Rael Storage, AL-19-018

Please accept the following comments from El Paso County Public Health regarding the proposed RV storage yard:

Mike McCarthy
El Paso County Public Health
Environmental Health Division
mikemccarthy@elpasoco.com
719.575.8602
12Sept2019

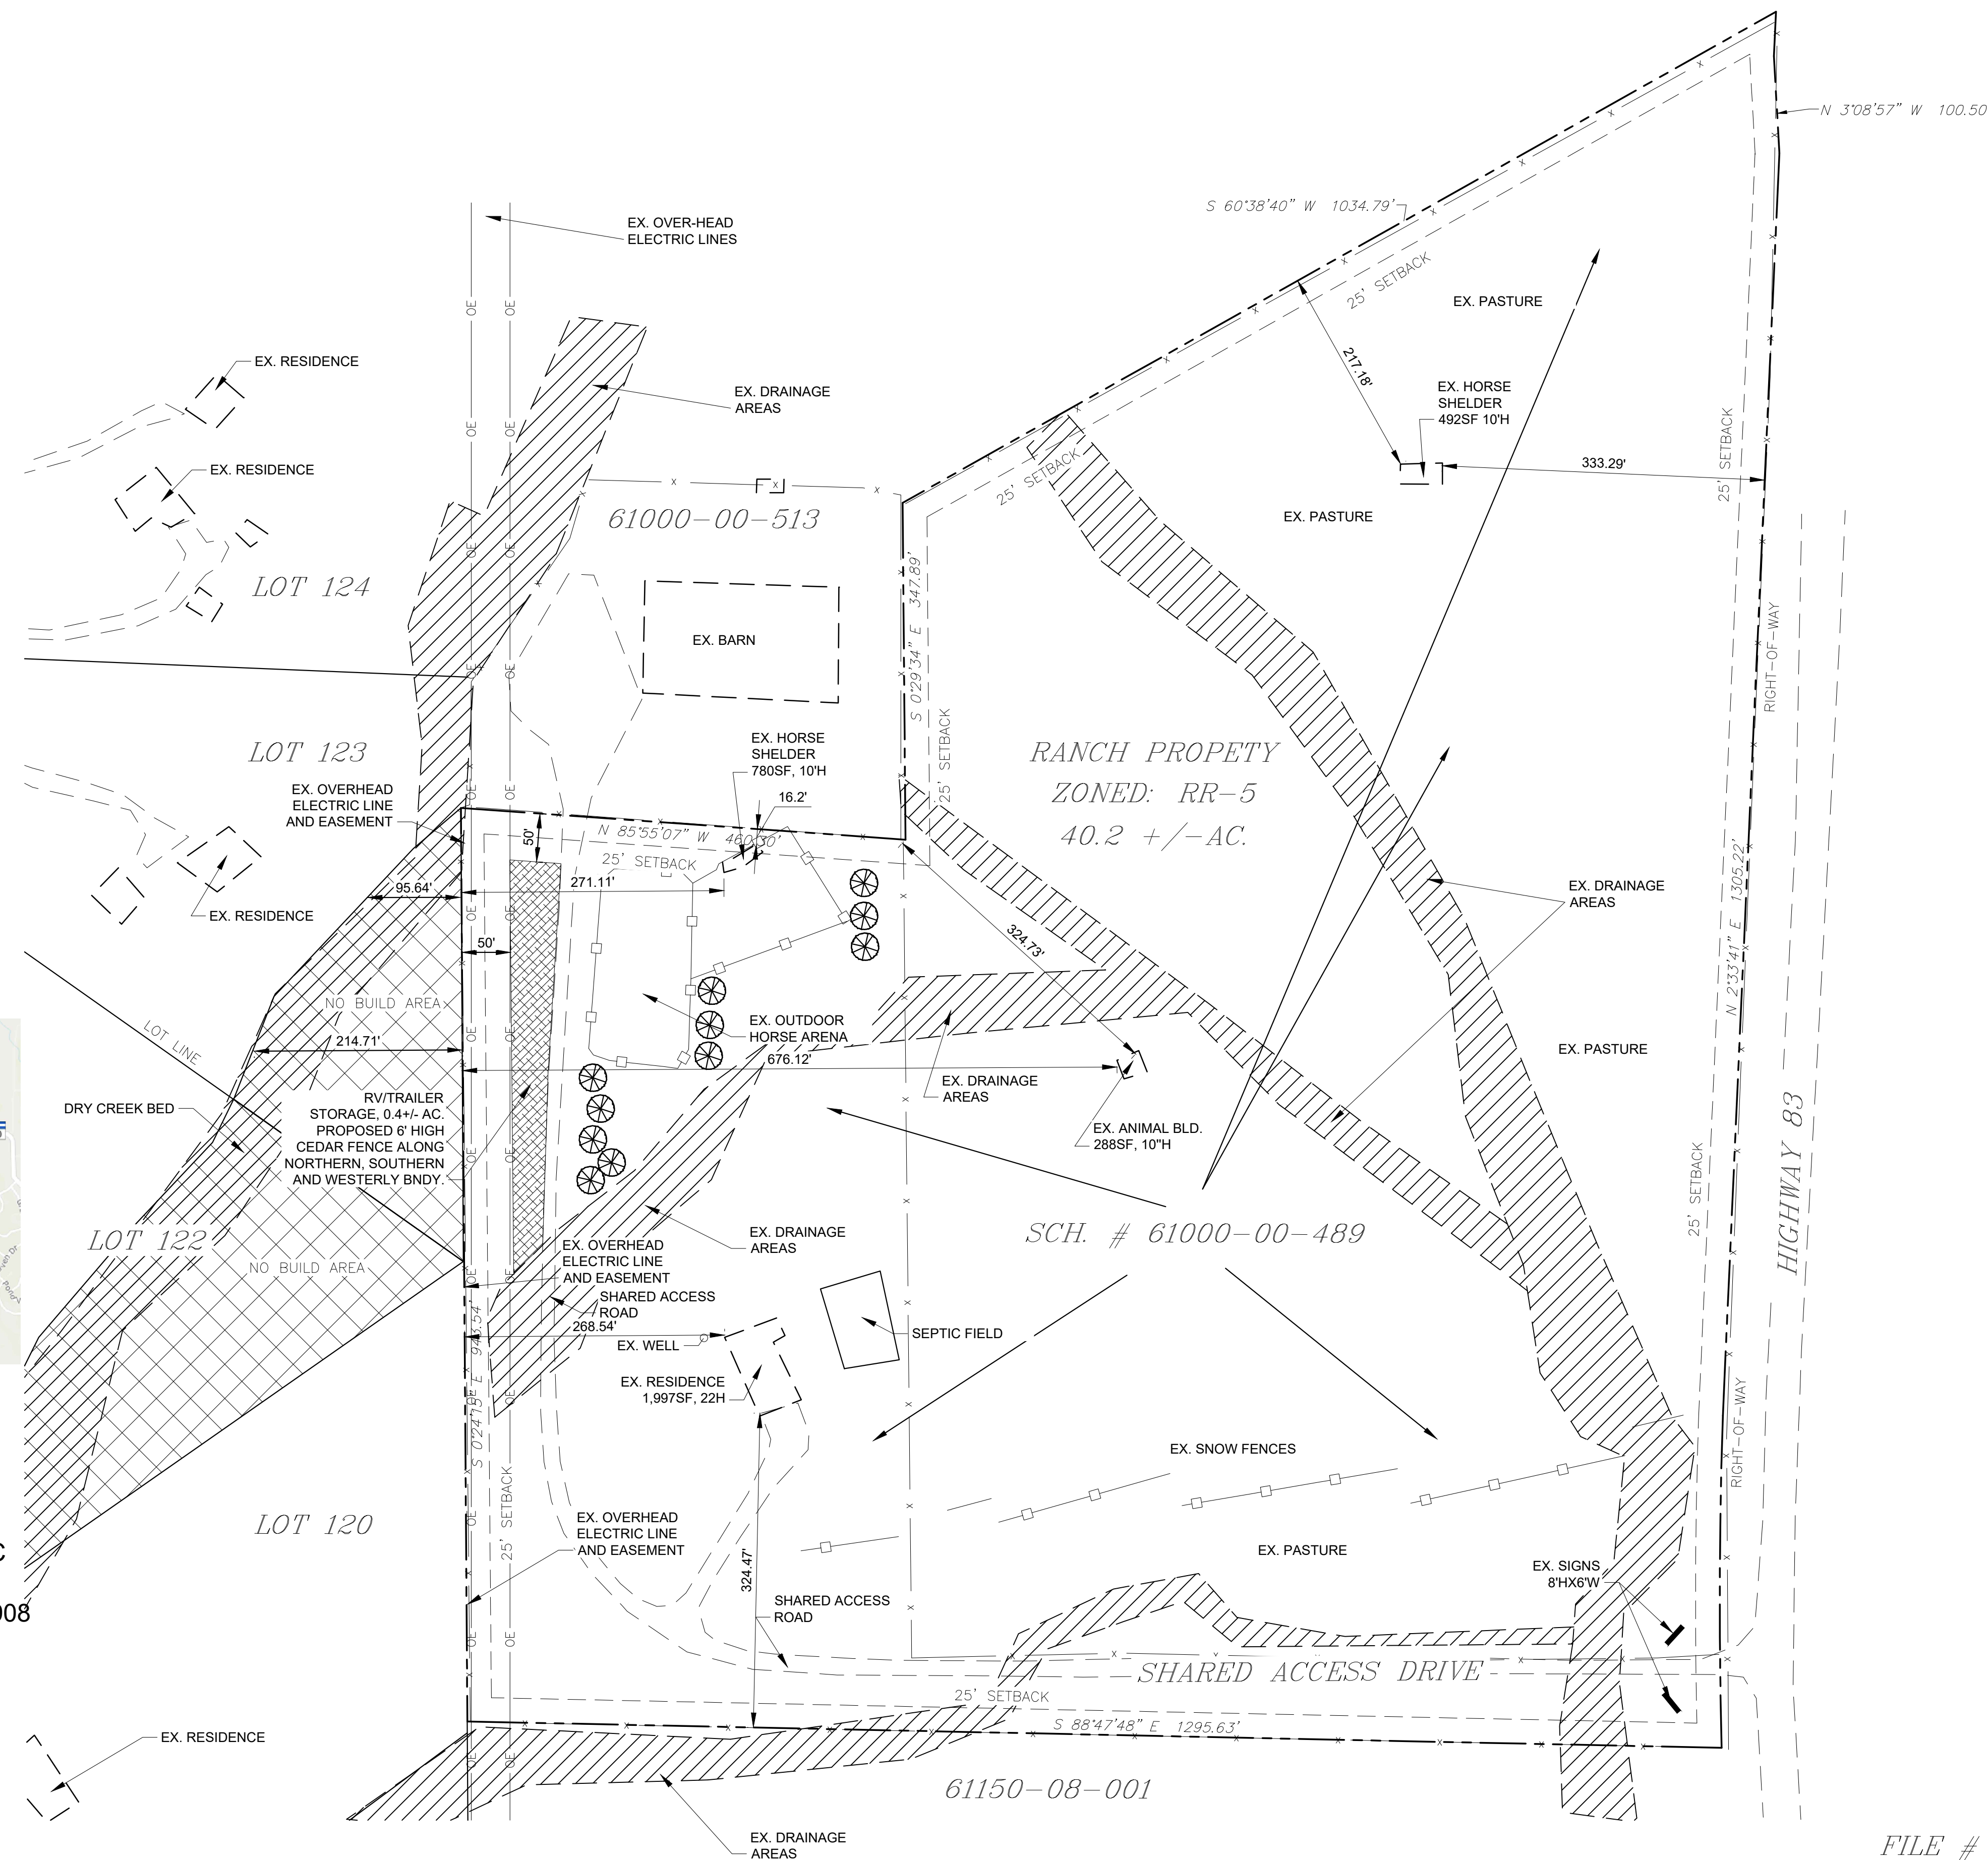
- **A record of a 2004 approved and permitted on-site wastewater treatment system (OWTS) for the existing house indicates the OWTS components are located on the north side of the house. Please make sure the existing OWTS soil treatment area (STA) and an equally sized STA replacement area remain protected from vehicular, livestock and other means of damage by compaction.**
- **No other public health issues noted with the proposal.**
